Arun District Council  
Arun Civic Centre  
Maltravers Road  
Littlehampton  
West Sussex BN17 5LF  
Planning & Building Control General Enquiries  
Tel: (01903) 737756 Fax: (01903) 730442  
Dx: 57406 Littlehampton  
Minicom: 01903 732765  
e-mail: [planning@arun.gov.uk](mailto:planning@arun.gov.uk)  
website: [www.arun.gov.uk/planning](http://www.arun.gov.uk/planning)

24th May 2021

Application No: EP/16/21/PL  
Site Address: Land East of 1 The Way East Preston BN16 1QJ  
Description of works: Replacement garage. This site is in CIL Zone 4 (Zero Rated) as other development.

Thank you for your internet representation made on 23rd May 2021 which has been recorded as an objection with the comments as follows:

Drawing Number: 1241.01.h

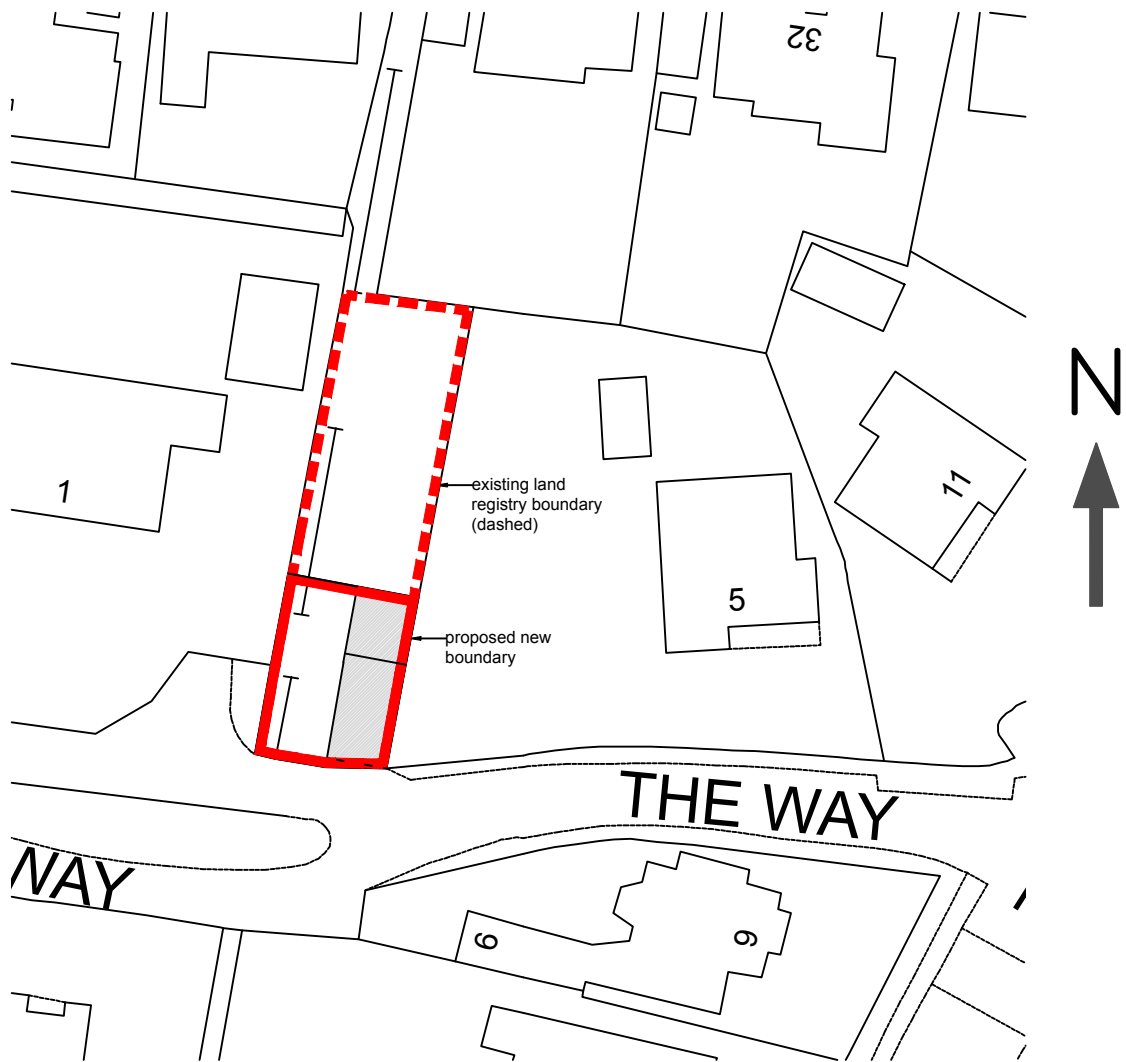
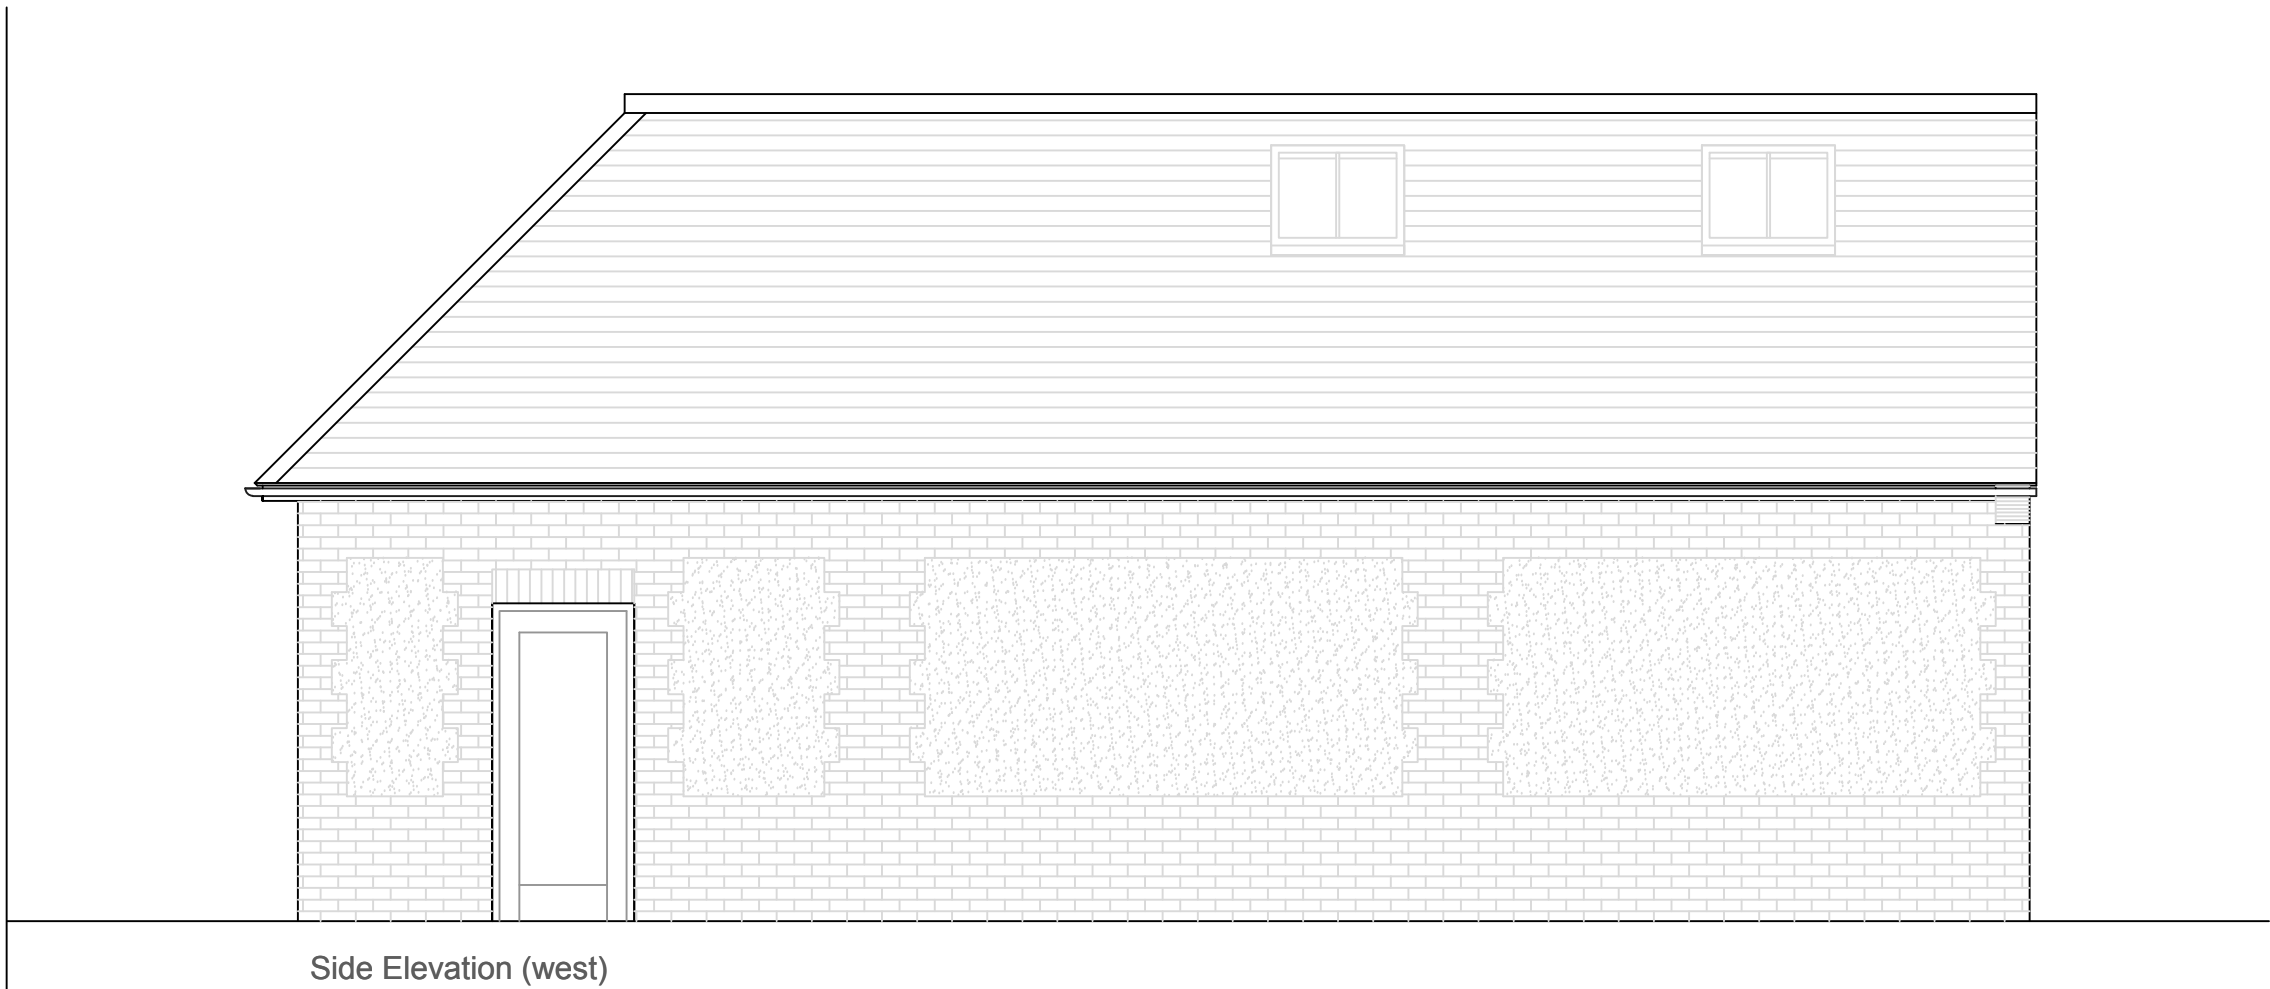
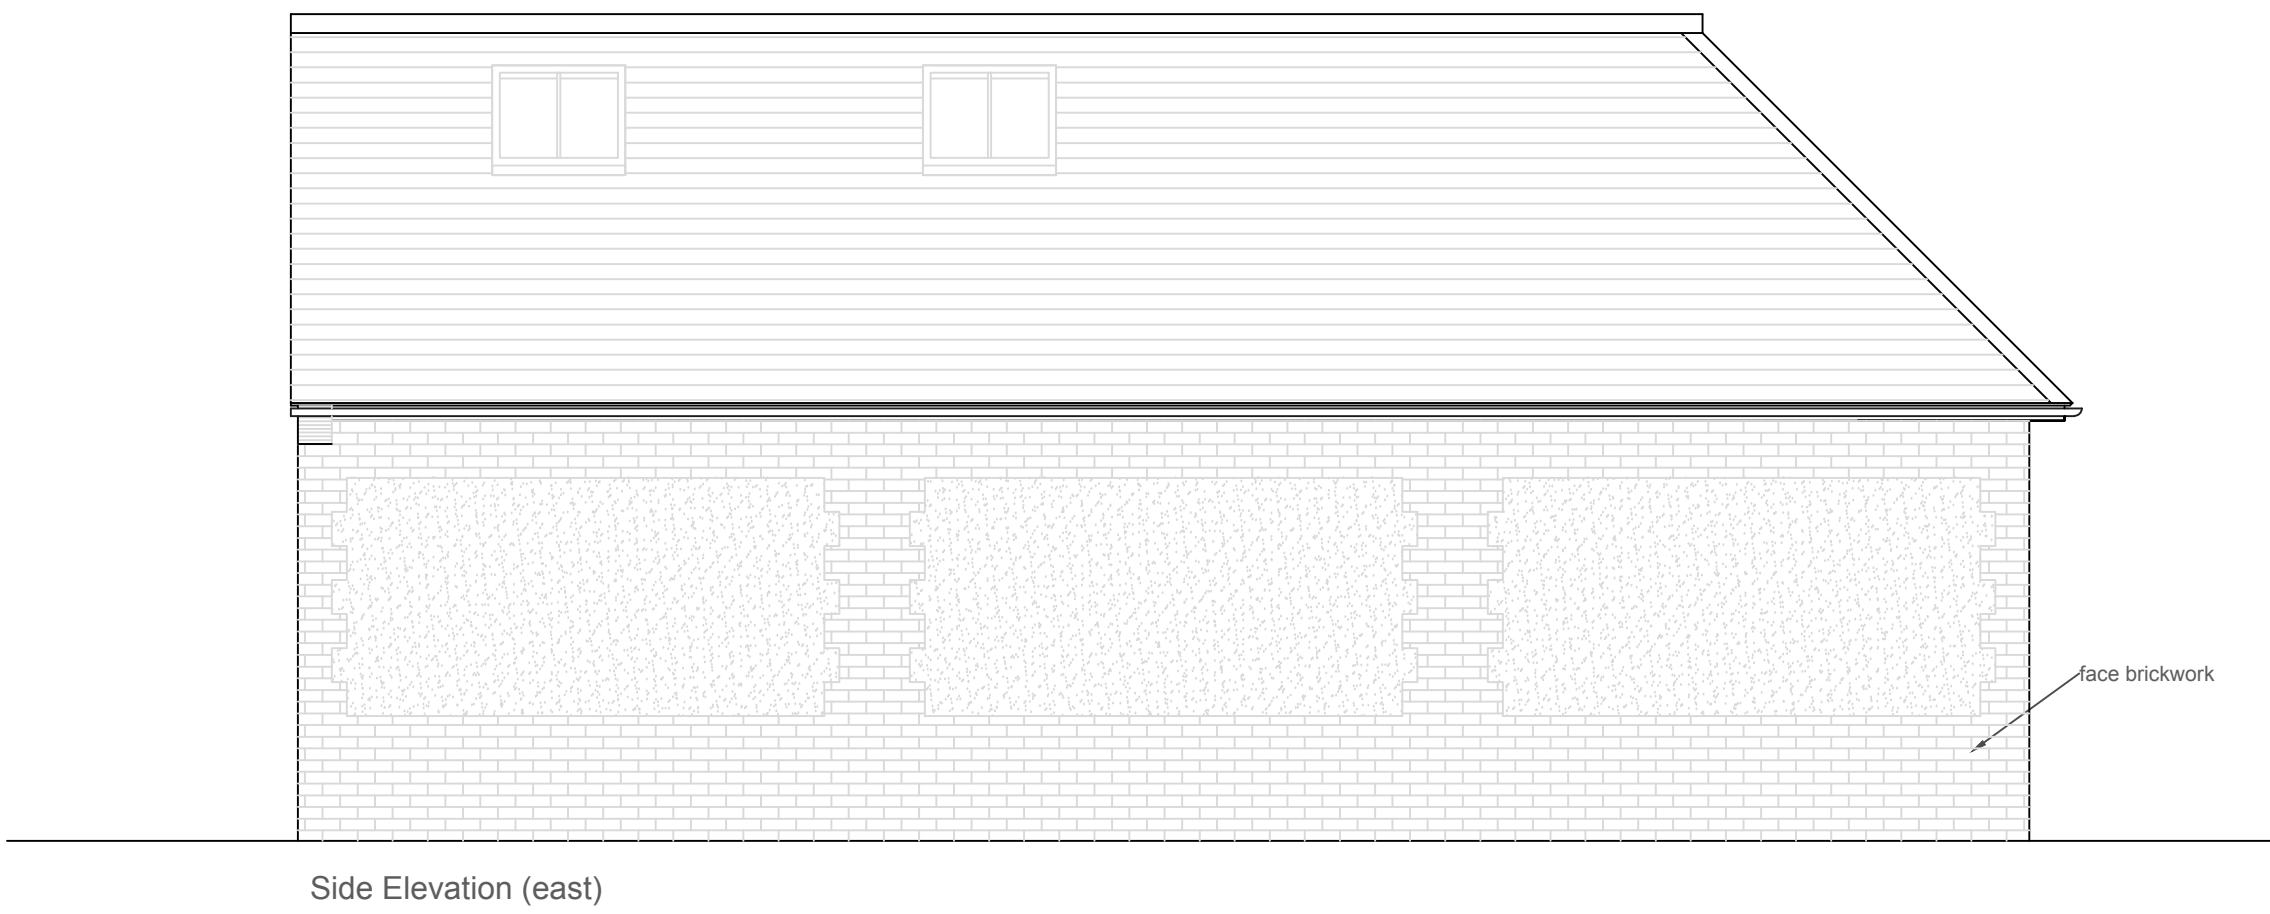
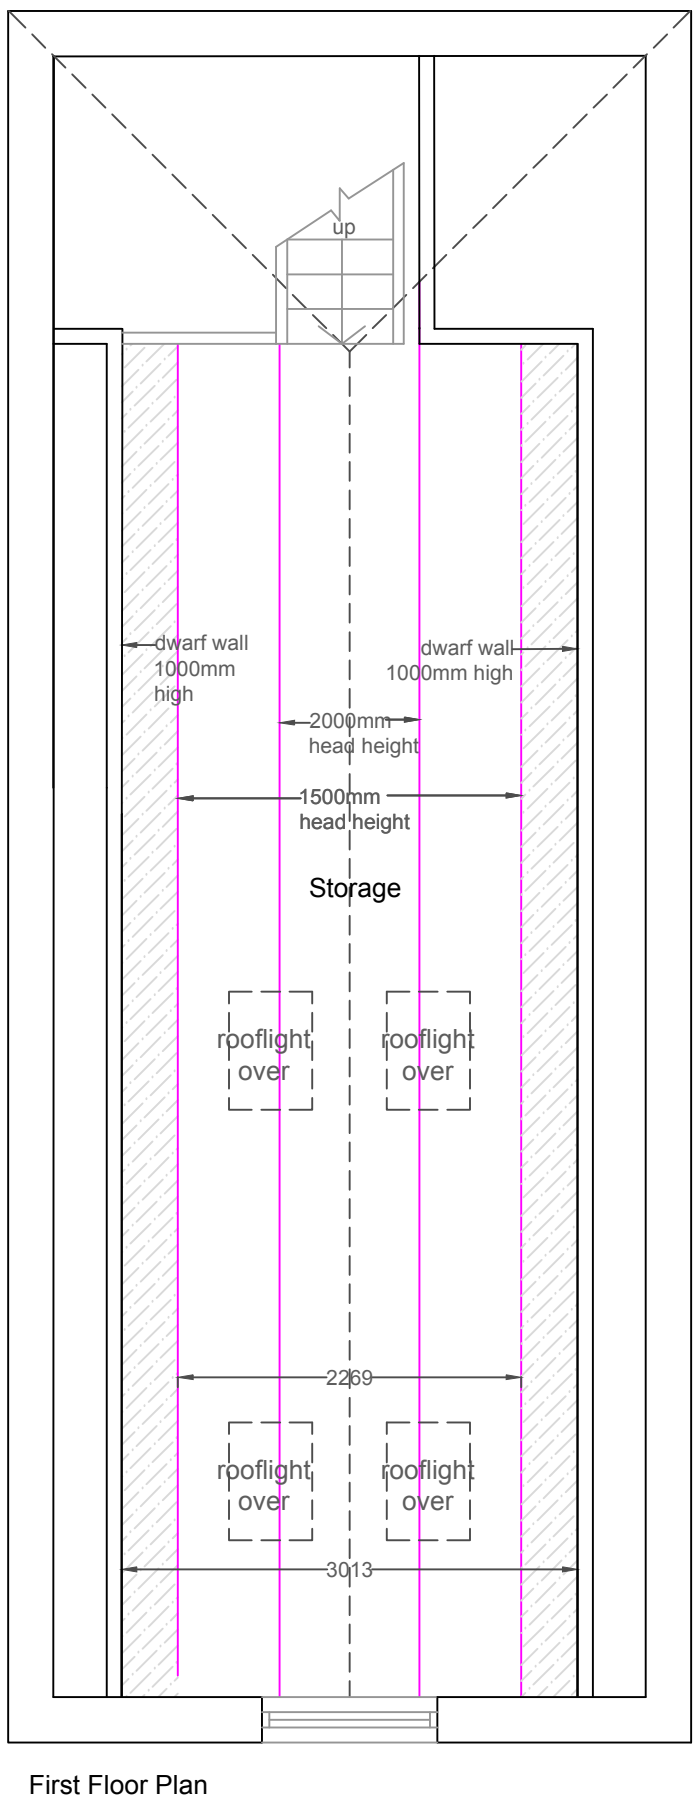
I note that the applicant has submitted a modification to the plan originally submitted. This modification (to the rear wall of the building proposed) has not addressed the issues upon which my original objection was based. These remain: a) the front elevation is disproportionately high for the street scene and is too close to the road to be either practical or in keeping b) the west side access door will require hard stand too close to the drainage ditch and in contravention of Arun drainage guidance c) the building proposed is not a 'replacement garage' as claimed but a two storey building with mixed use likely on the second storey; the application terminology misrepresents the reality of the proposal.
